At this stage we **would not recommend discharge of conditions** until the following comments are addressed.

FOR CONTINUATION SEE DRAWING P1847-BAK-XX-XX-DR-C-502

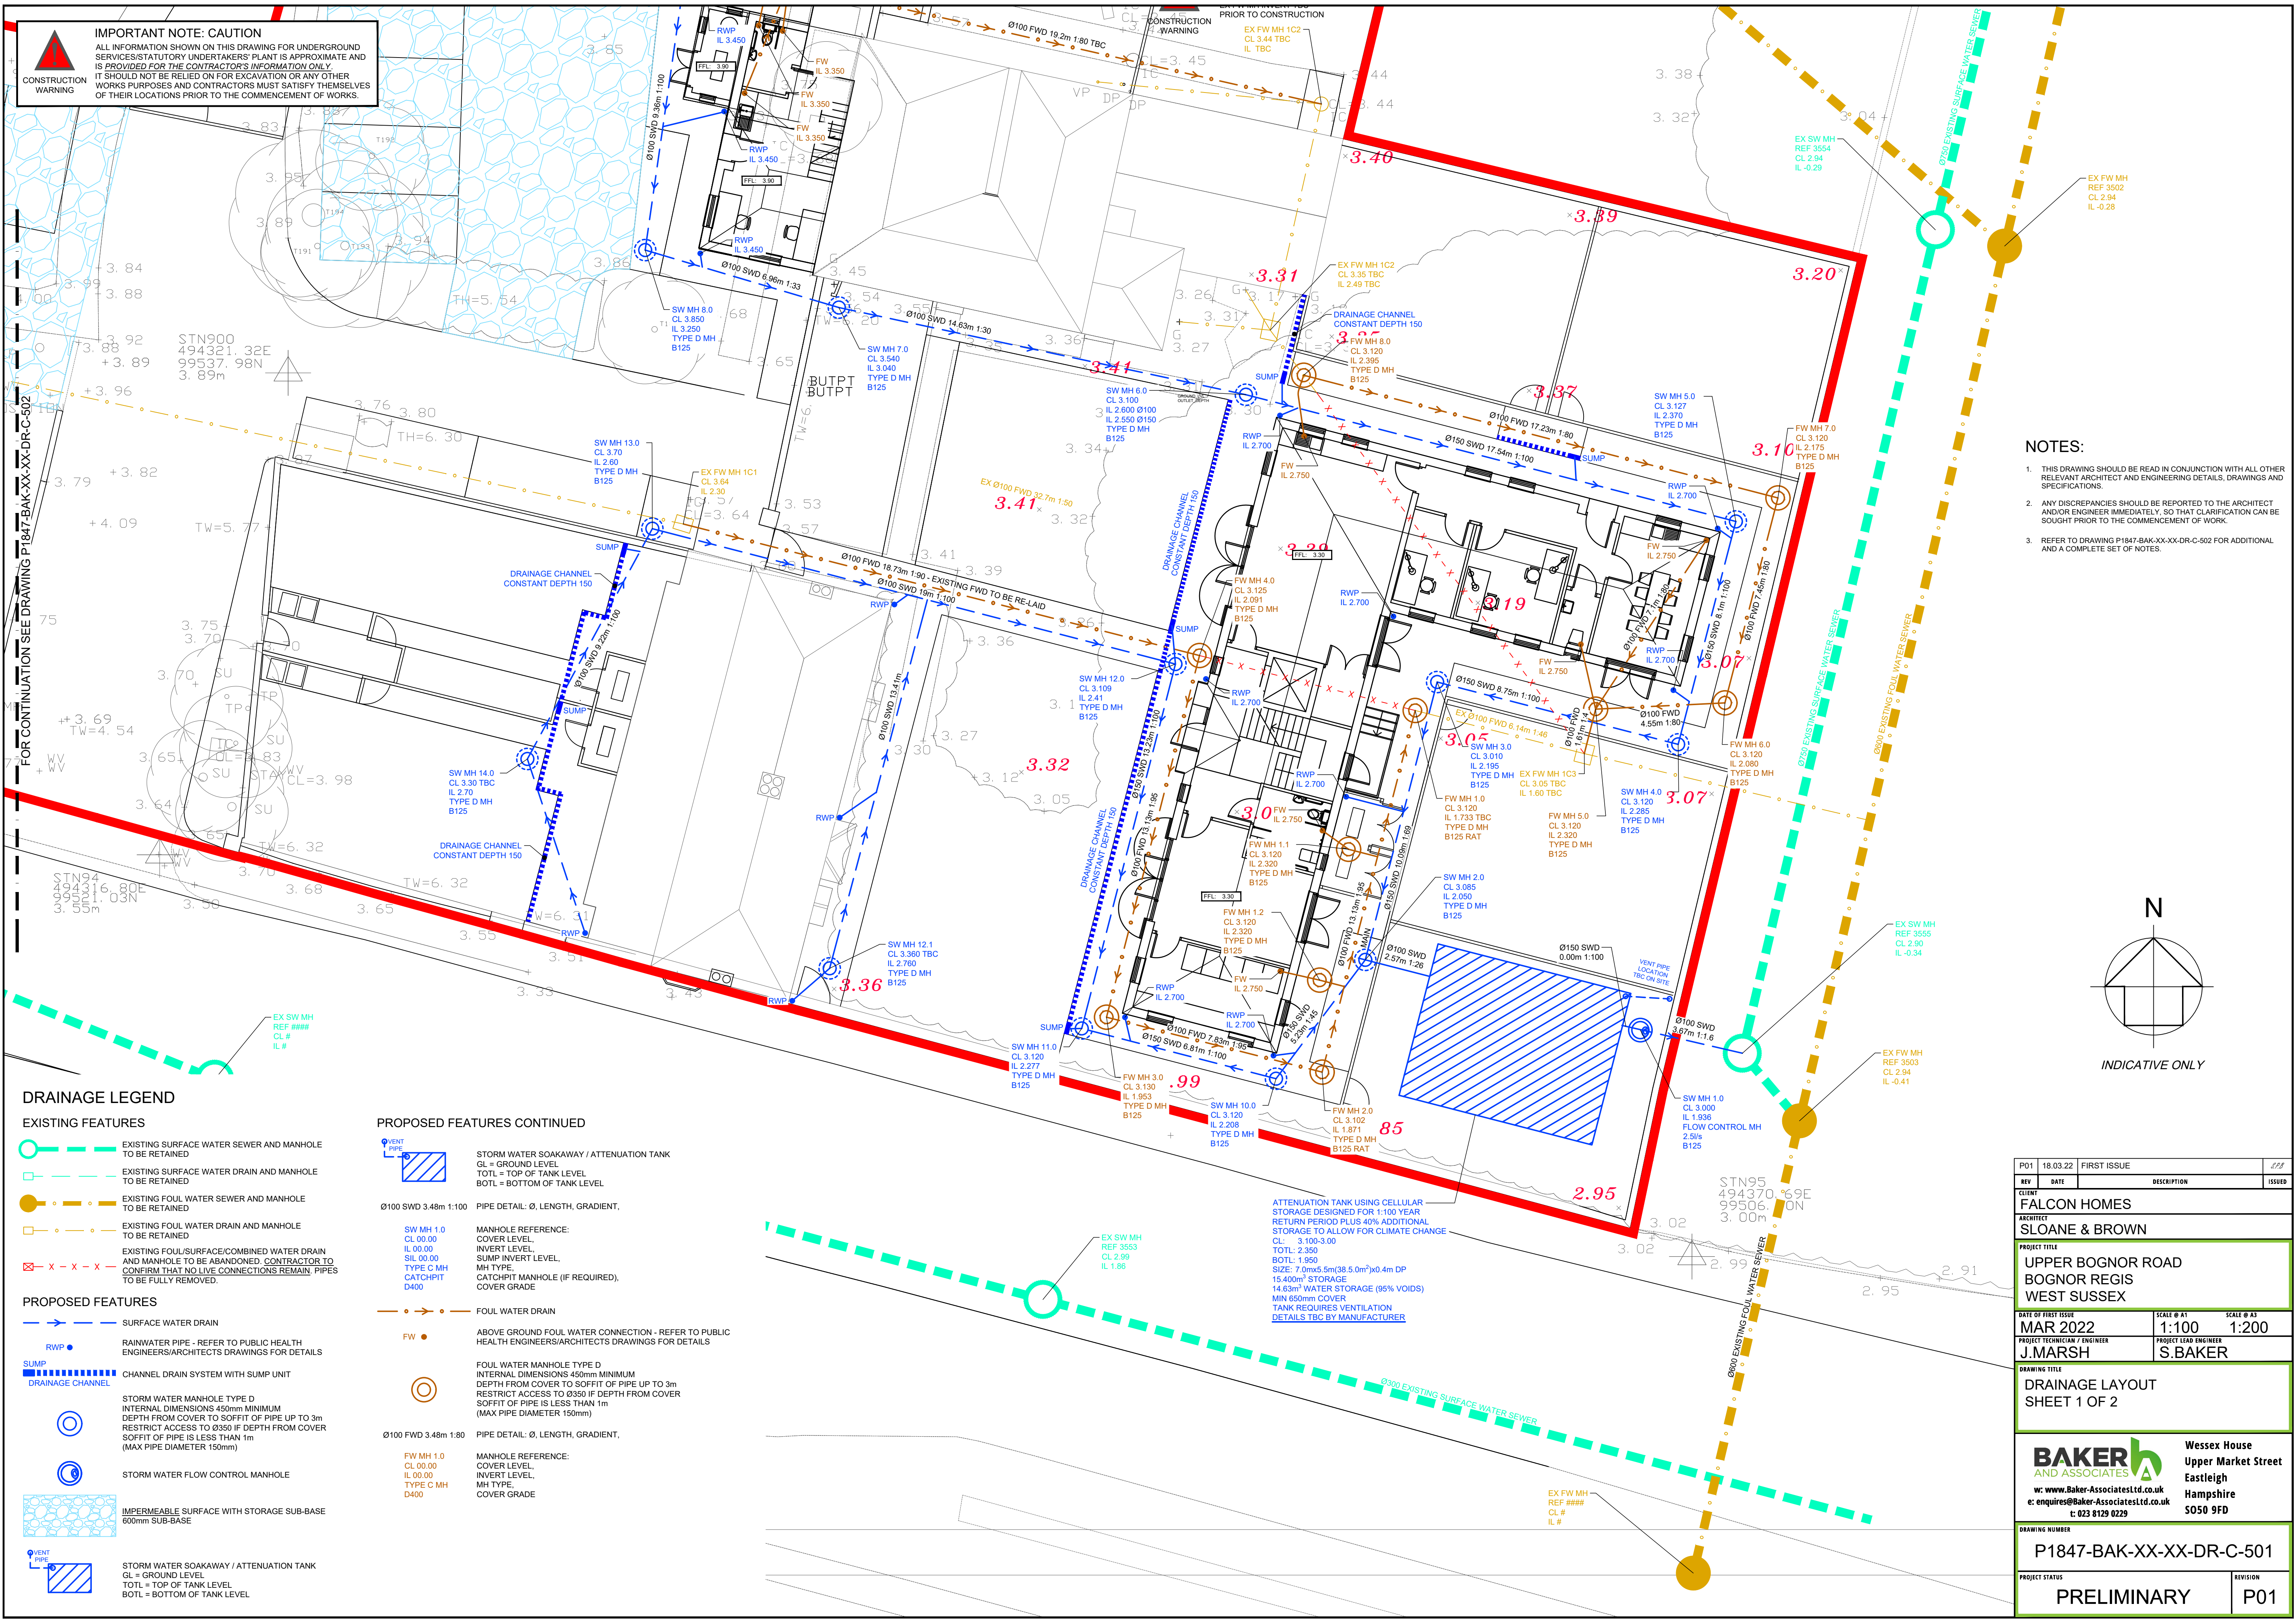
1. The proposed drainage is reliant on a connection to a surface water sewer which shows characteristics consistent with it being an error on Southern Waters mapping system. As a result, we would request the applicant confirms the drainage network in this location with a survey.

- We require evidence from the applicant that the outfall intended for use does actually exist as shown on the drainage plans and is not an error on the mapping.

- Notwithstanding this, even if the network is shown as Southern Water indicate, we would refuse a connection into the large surface water pipe as currently shown, as it appears that this pipe discharges directly into the adjacent foul network. Consequently, revisions to the point of connection between the site and public sewer system are likely to be required.

- It is recognised that if unachievable and justifiable, 2.5l/s would be considered acceptable given the existing site is partly developed.
 11. The inlets into the geo-cellular storage tank must be designed to ensure they are above the maximum water level in the tank during the critical duration storm with a 1:10 year return period. The section drawing of the attenuation tank, and invert levels on the drainage drawing suggest this has not been achieved.

14. The pipe between MH11 and MH10 is shown to drain uphill. This should be corrected.
 15. Water quality criteria have not been met. Information on the water treatment provided by the scheme should be provided.

18. The crate type and manufacturer specification should be provided.
 19. Catchpits should be included within the design (upstream of the geo-cellular storage tank), and design details provided.

- Overflow systems can be used as an alternative, but will require justification and are subject to approval.
 22. We note that the 'sump available' option has been used in the drainage model/calculations. If a Hydro-Brake with sump available is specified, as is indicated by the results sheets submitted, this sump will need to be included on the detailed drainage drawings.

- S9 PLASTIC PAVING GRID REINFORCEMENT WITH GRAVEL FILL
- PERMEABLE SURFACE WITH STORAGE SUB-BASE

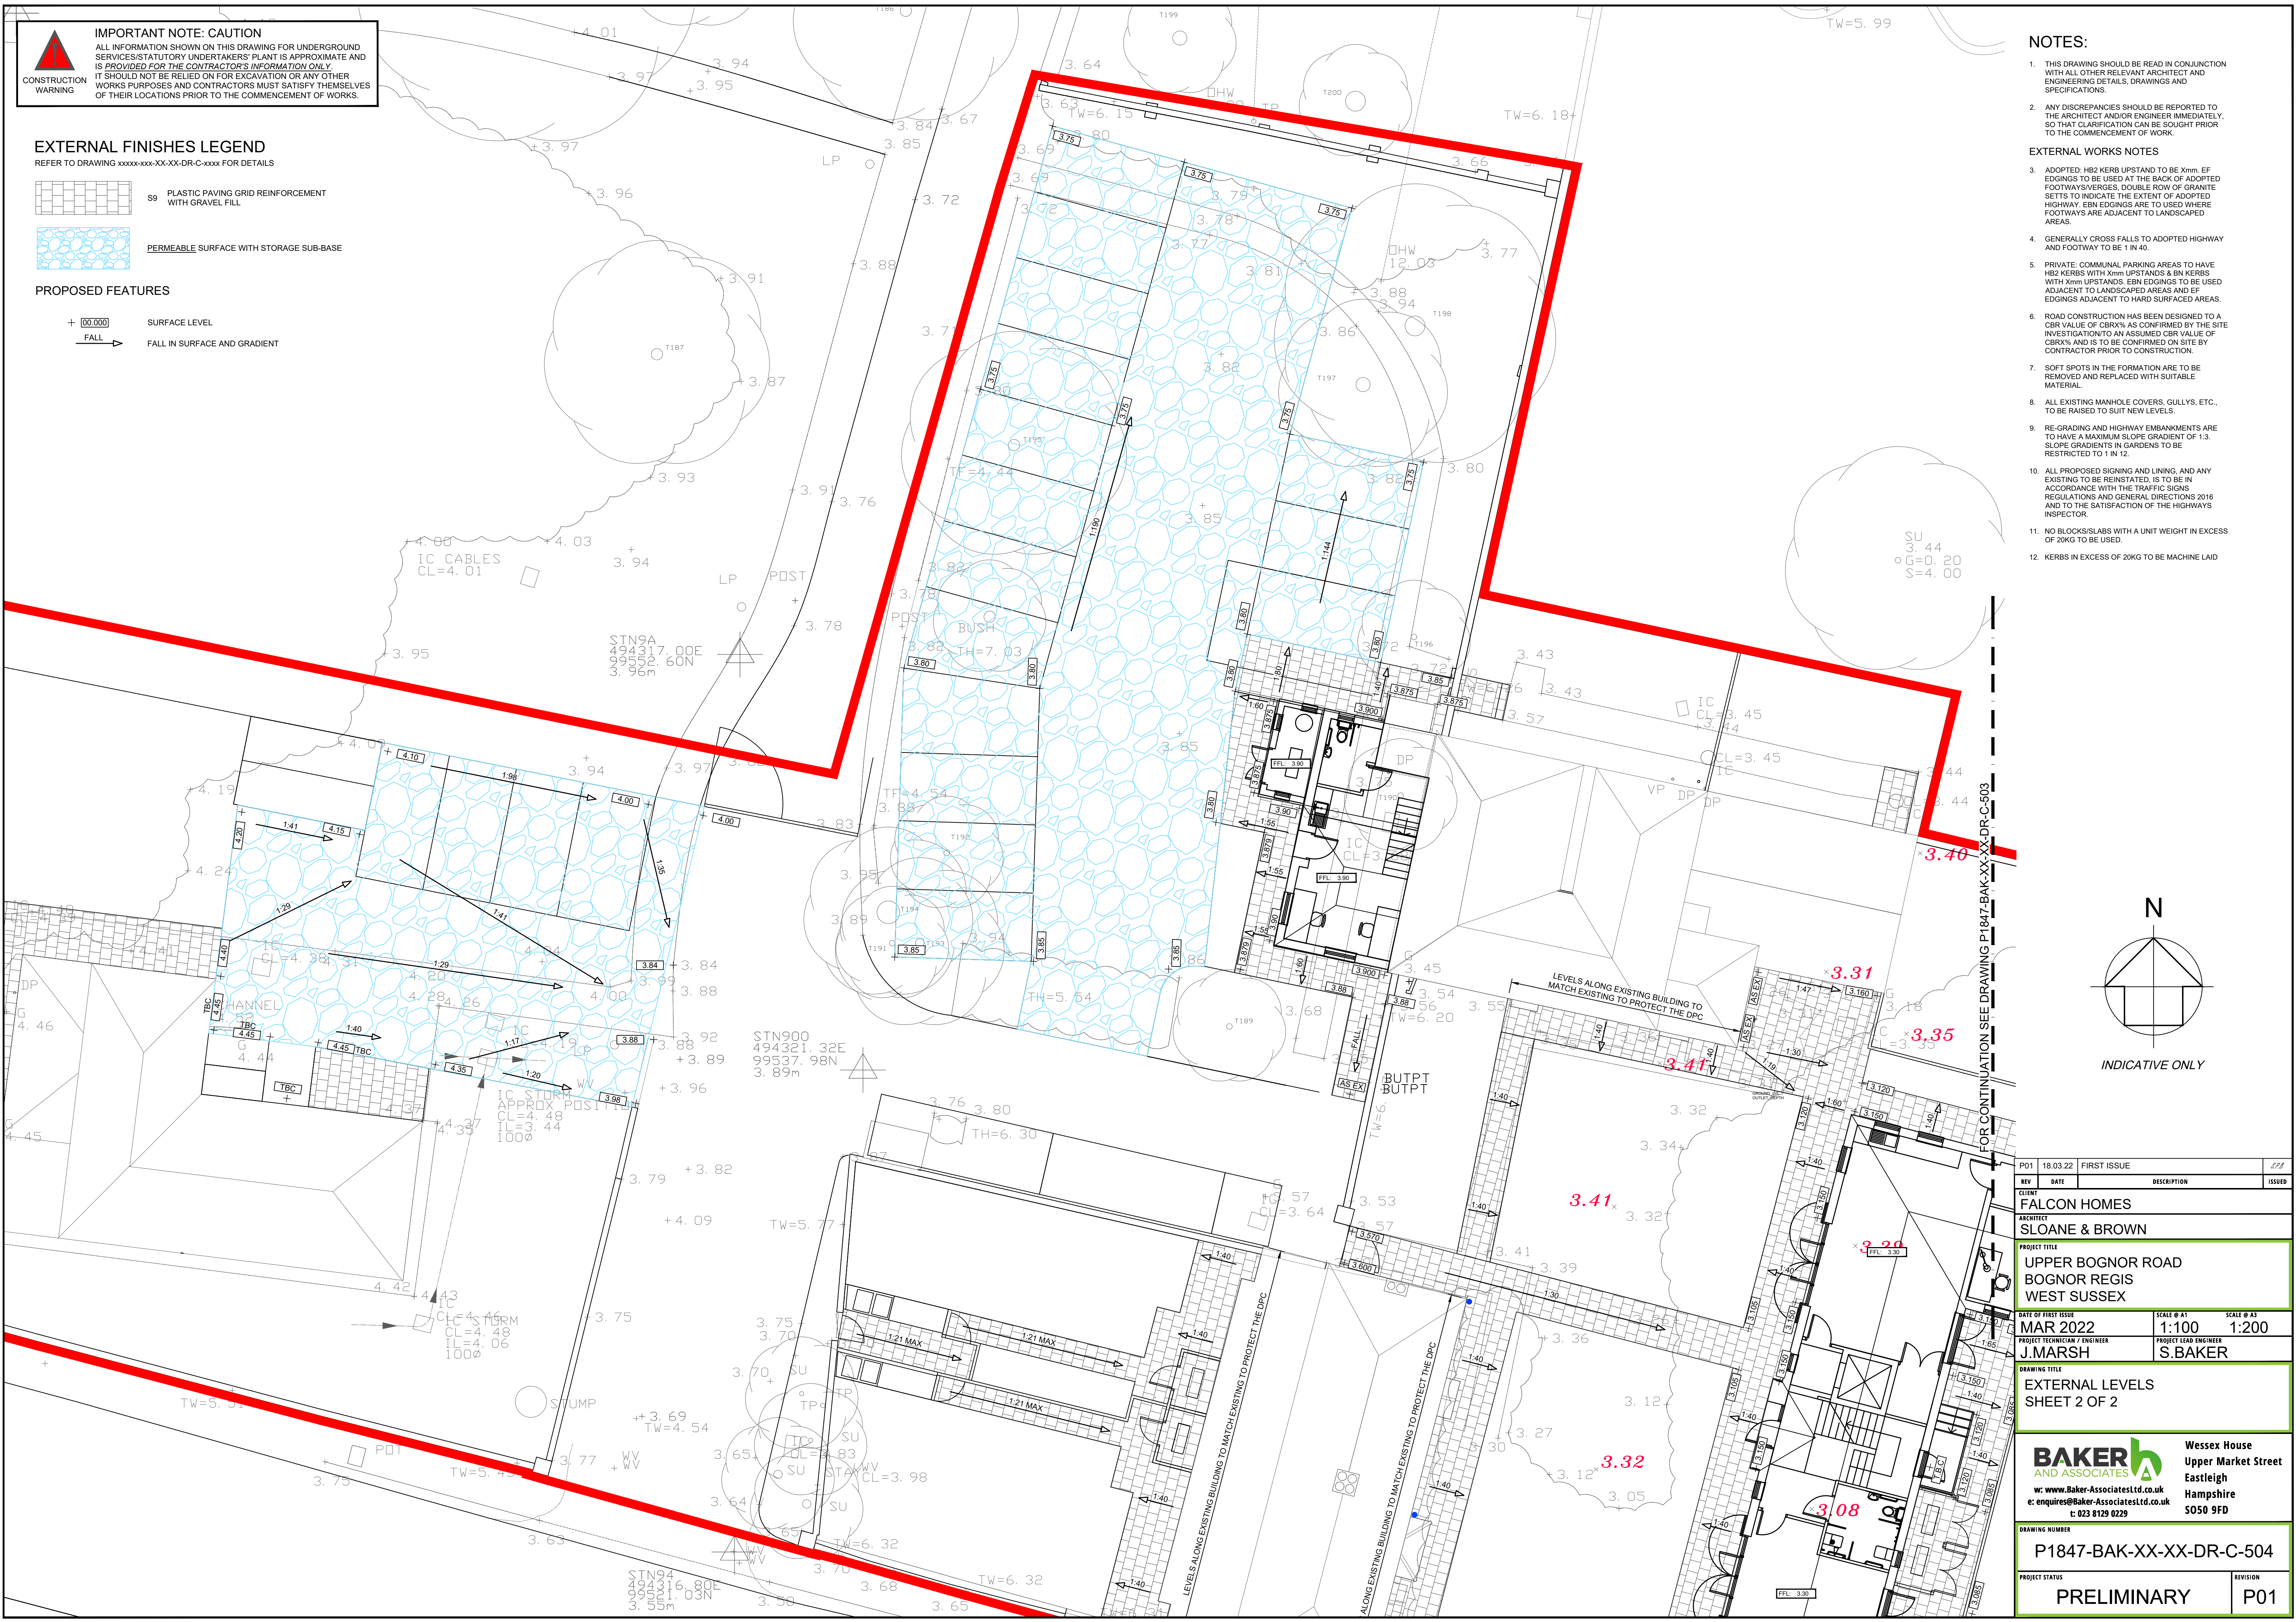
7. The Type 1 sub-base proposed for the carparking needs to be replaced by an aggregate with a low content on fine material, e.g. Type 3 aggregate to ensure sufficient infiltration occurs.

TYPICAL DETAIL FOR ATTENUATION TANK

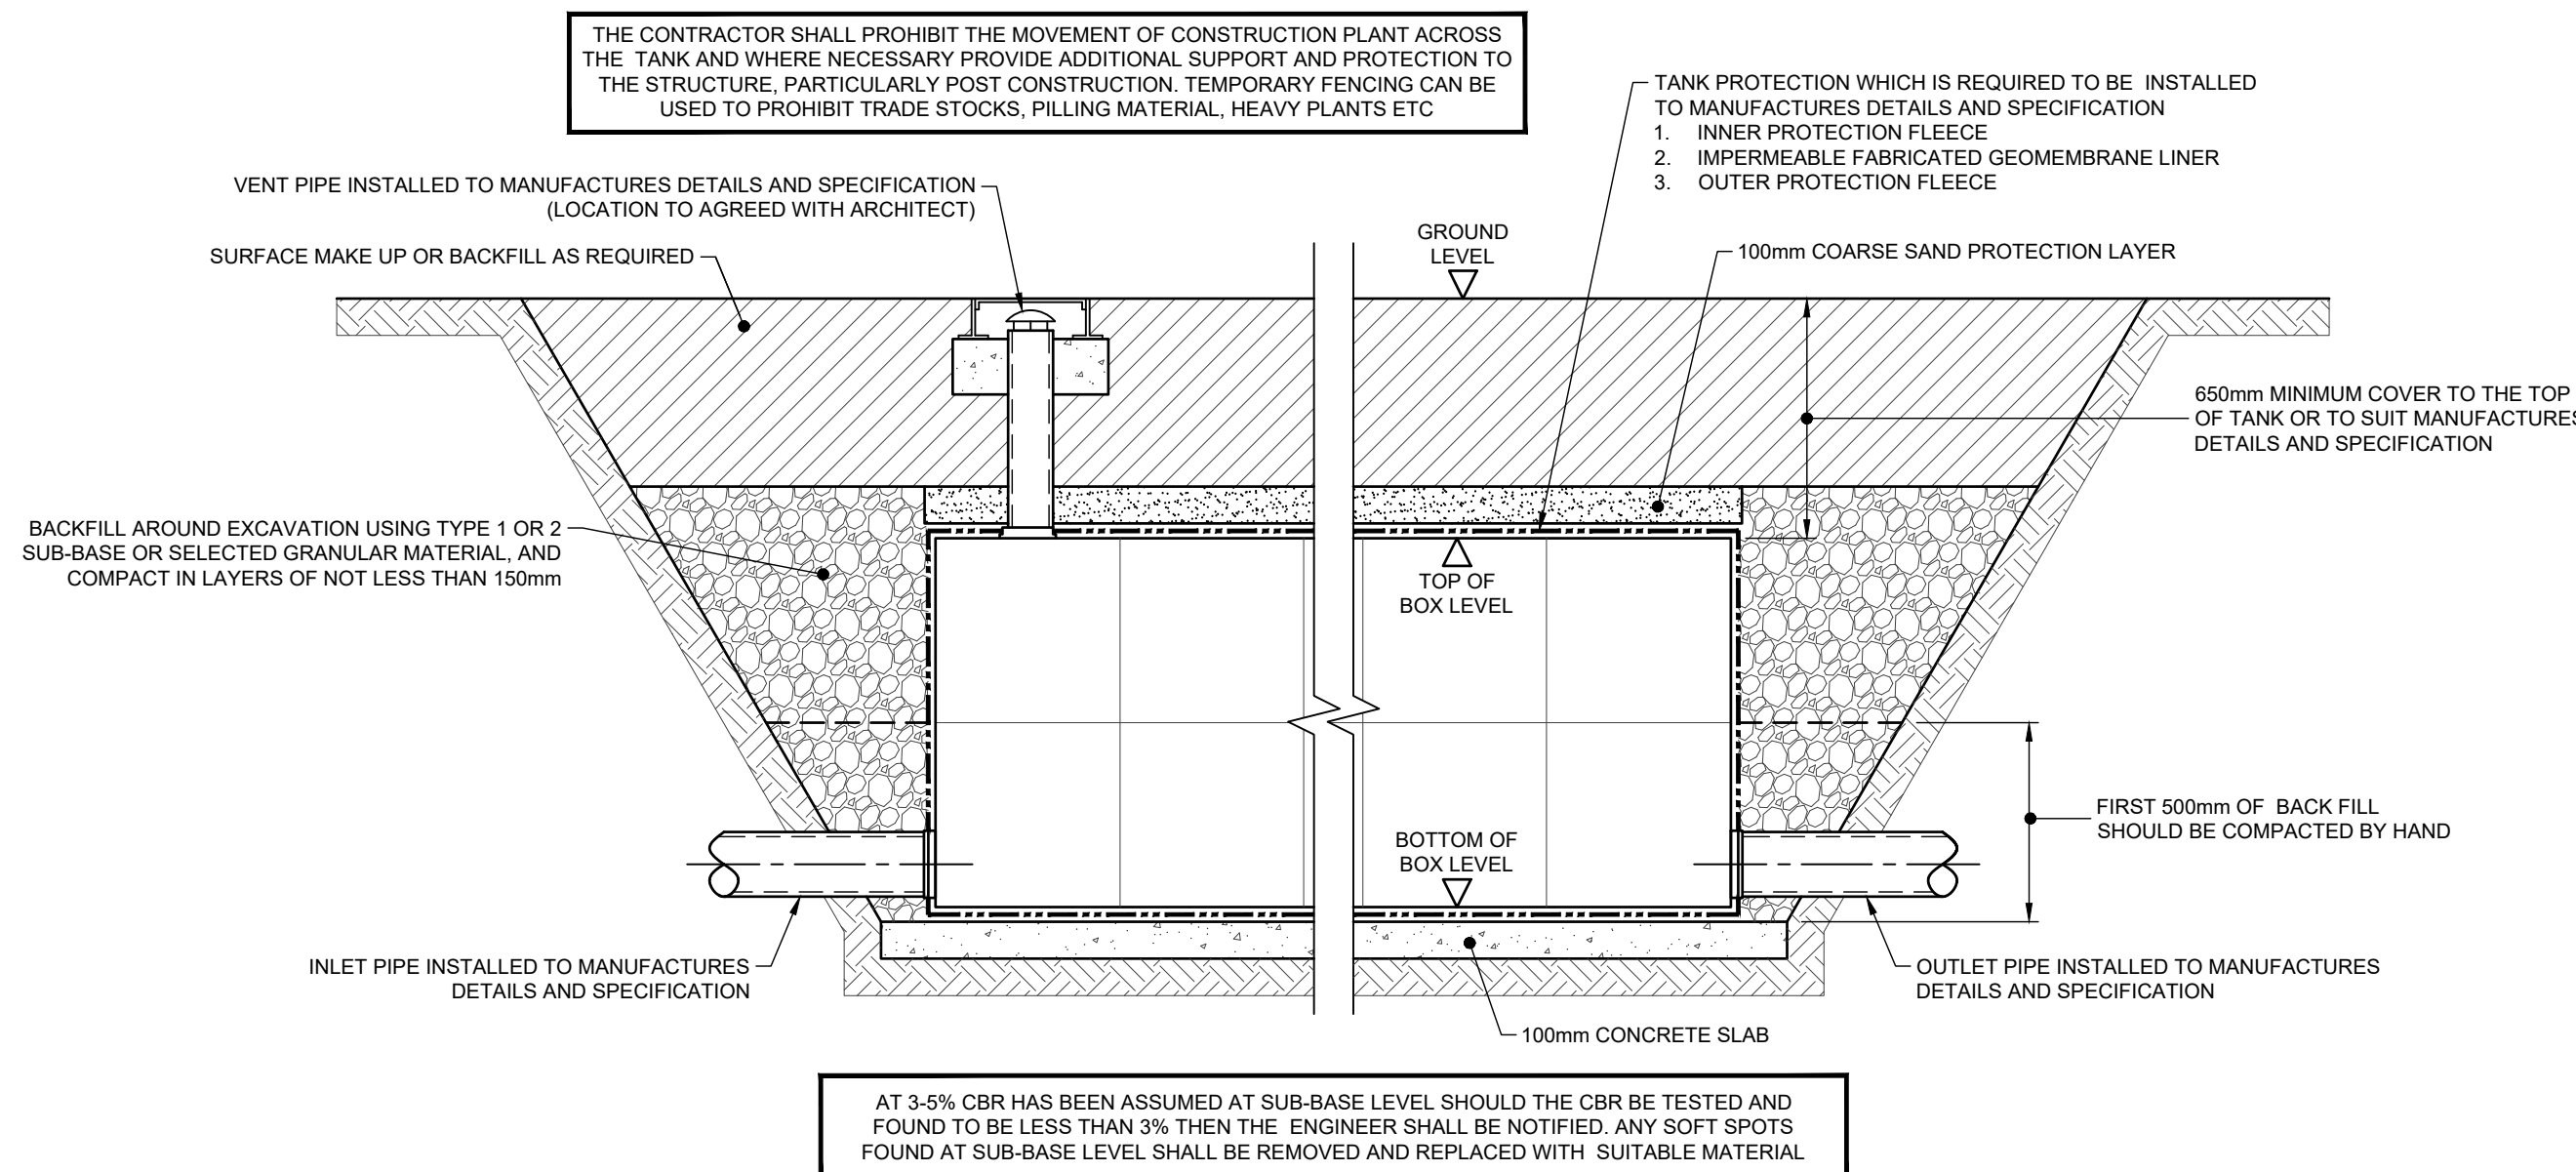
- The type of geotextile membrane (impermeable or permeable) should be stated on the retention system section drawing.
 - Details of the proposed flow control device should be provided.

- Even in the event that the worst case groundwater level is assumed to be 1.1m BGL, the base of the tank is shown to be almost at, or below the water table.

- Details of how the geo-cellular storage tank will be inspected during maintenance should be provided, e.g. will this be undertaken by CCTV drainage survey similar to the pipework?, or will the tank include access covers for visual inspection?
